FP/194/14/PL
Cover letter

**Re: Meadowskeep, Blakesmead, Felpham: Barratt Development
Planning Application No. FP/224/11**

Drawing No.
D1530 L.303

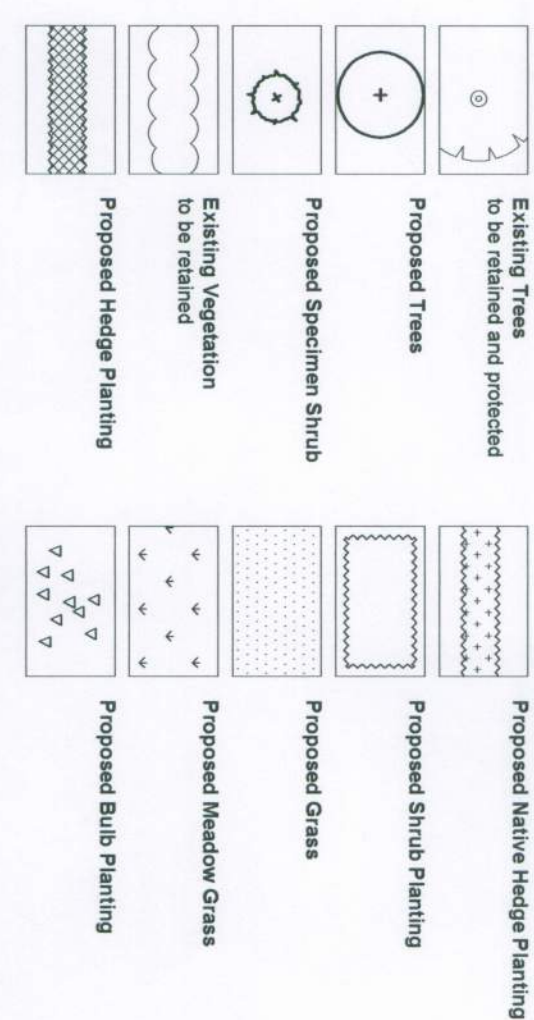
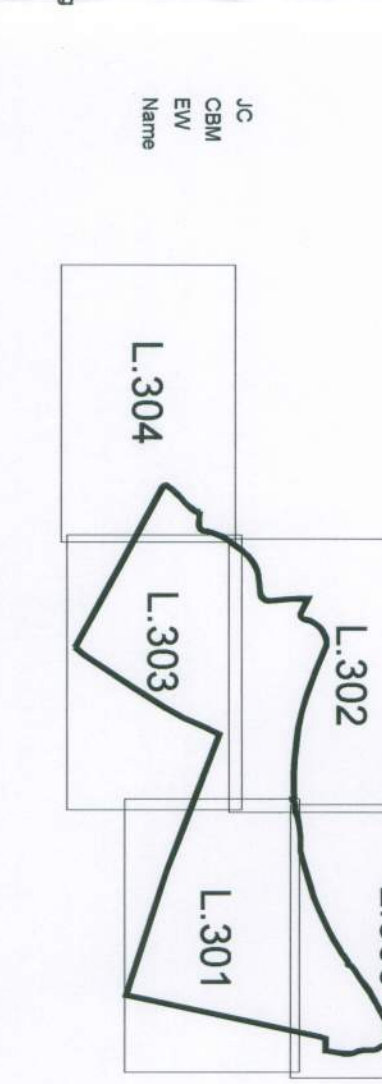
Plot 287:

- Change in position of boundary in rear garden to reflect the adjustment in siting of plots 288 & 289.
- Change in landscaping to reflect rear boundary change.

Plot 288:

- Change in siting of plot to reflect the as built scenario.
- Omission of single detached garage and replacement with 1 no parking space.
- Change in landscaping to reflect rear boundary change.

Plot 289:

- Change in siting of plot to reflect the as built scenario.
- Repositioning single detached garage.
- Change in landscaping to reflect rear boundary change.
- Provision of new wall to boundary bordering development.

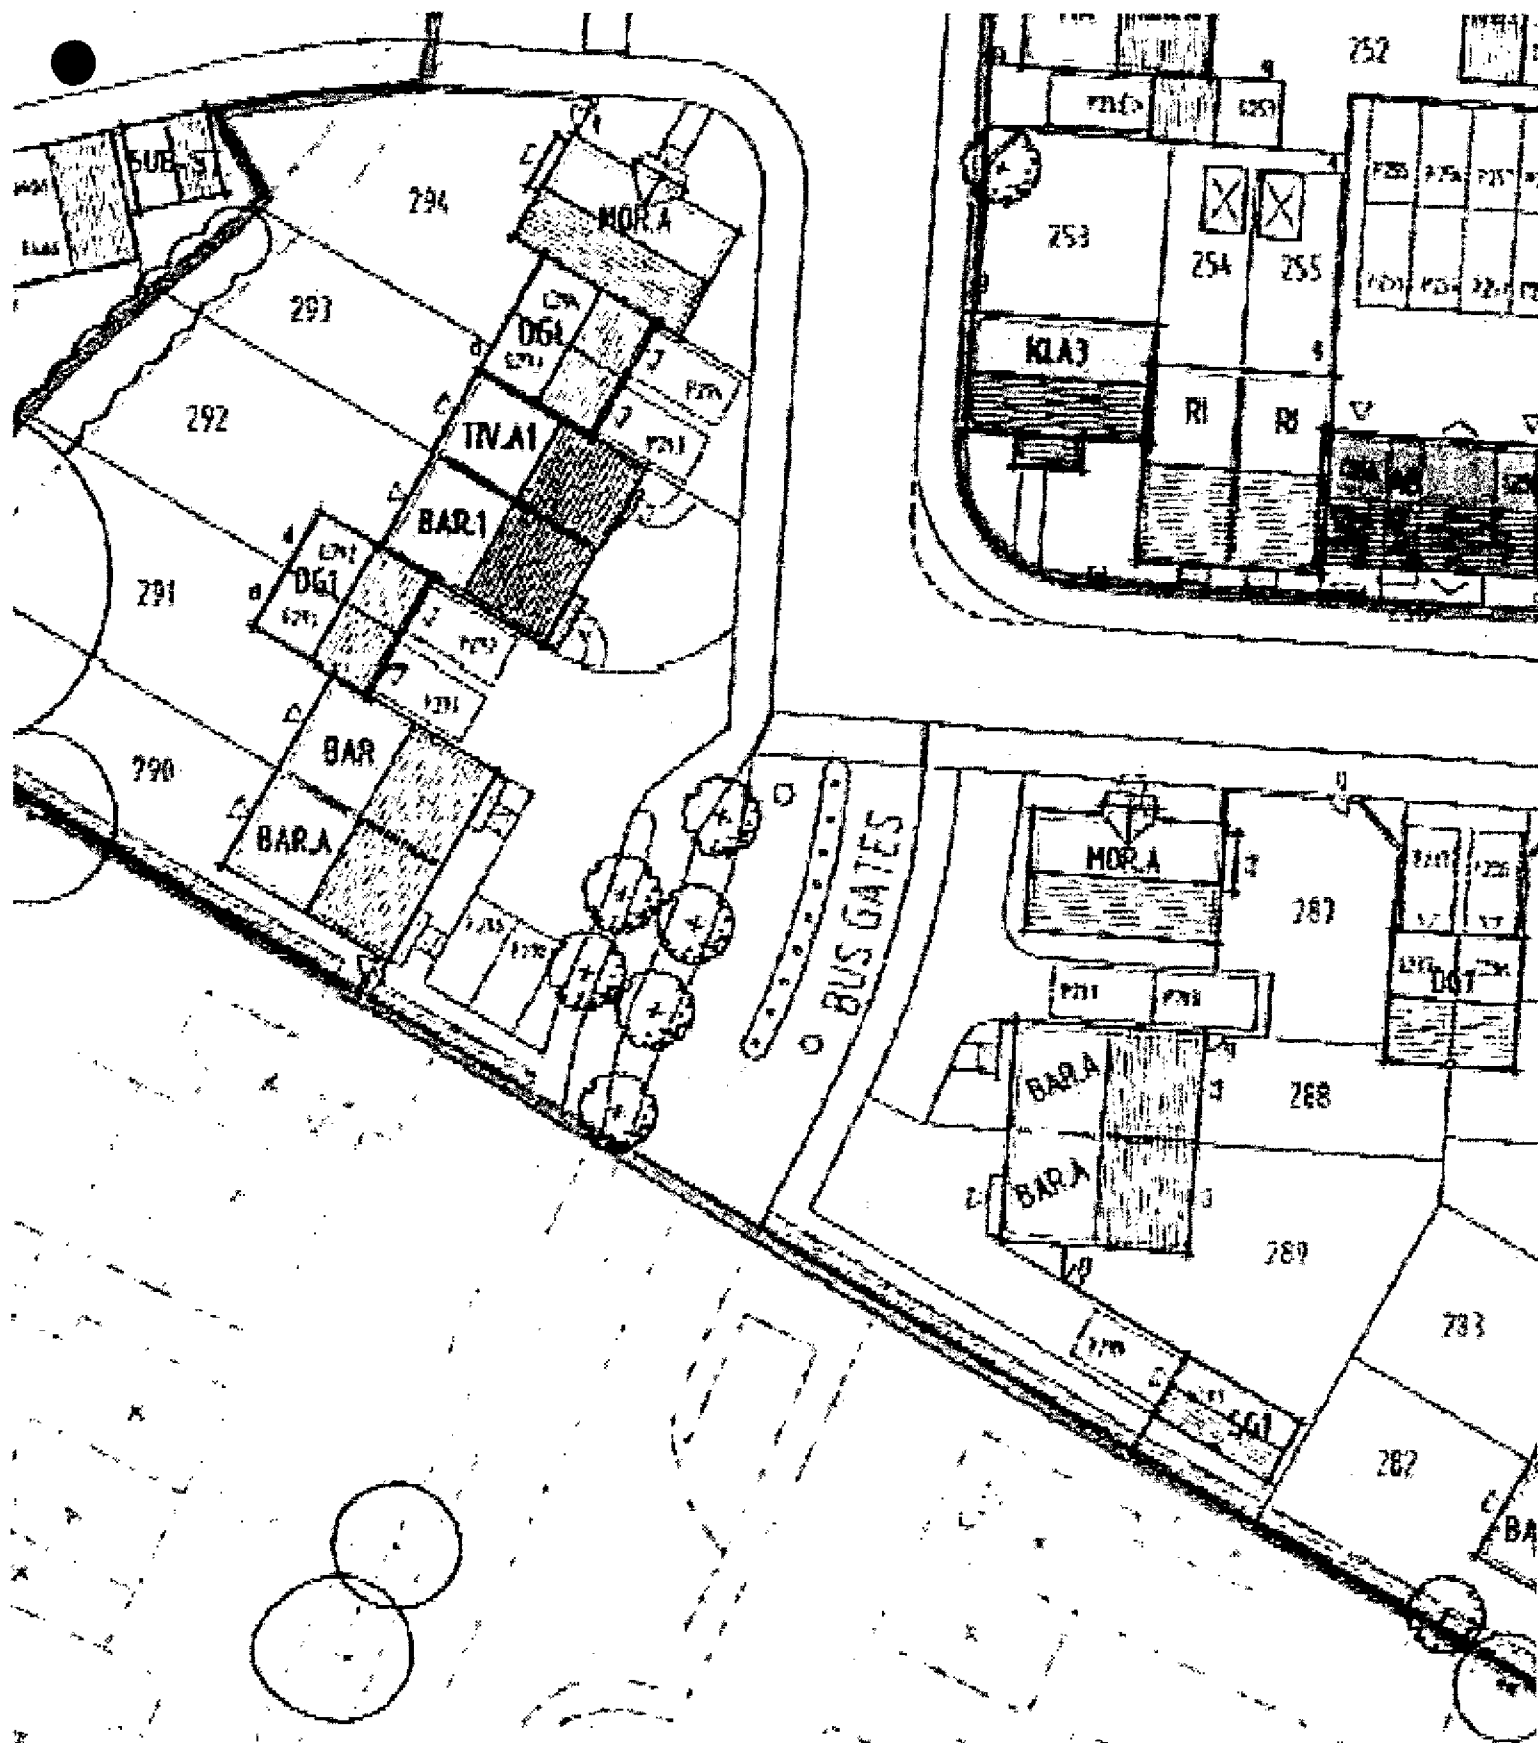
We will provide a 2m high brick wall which will screen the property from the development. The wall will begin at the front of the drive and return to the front of the garage as shown on the attached drawing (EXT-WKS_PH2_110113-05-J). The wall will have brick piers as requested and we will provide a planting border between the gap at the side of the property and drive.
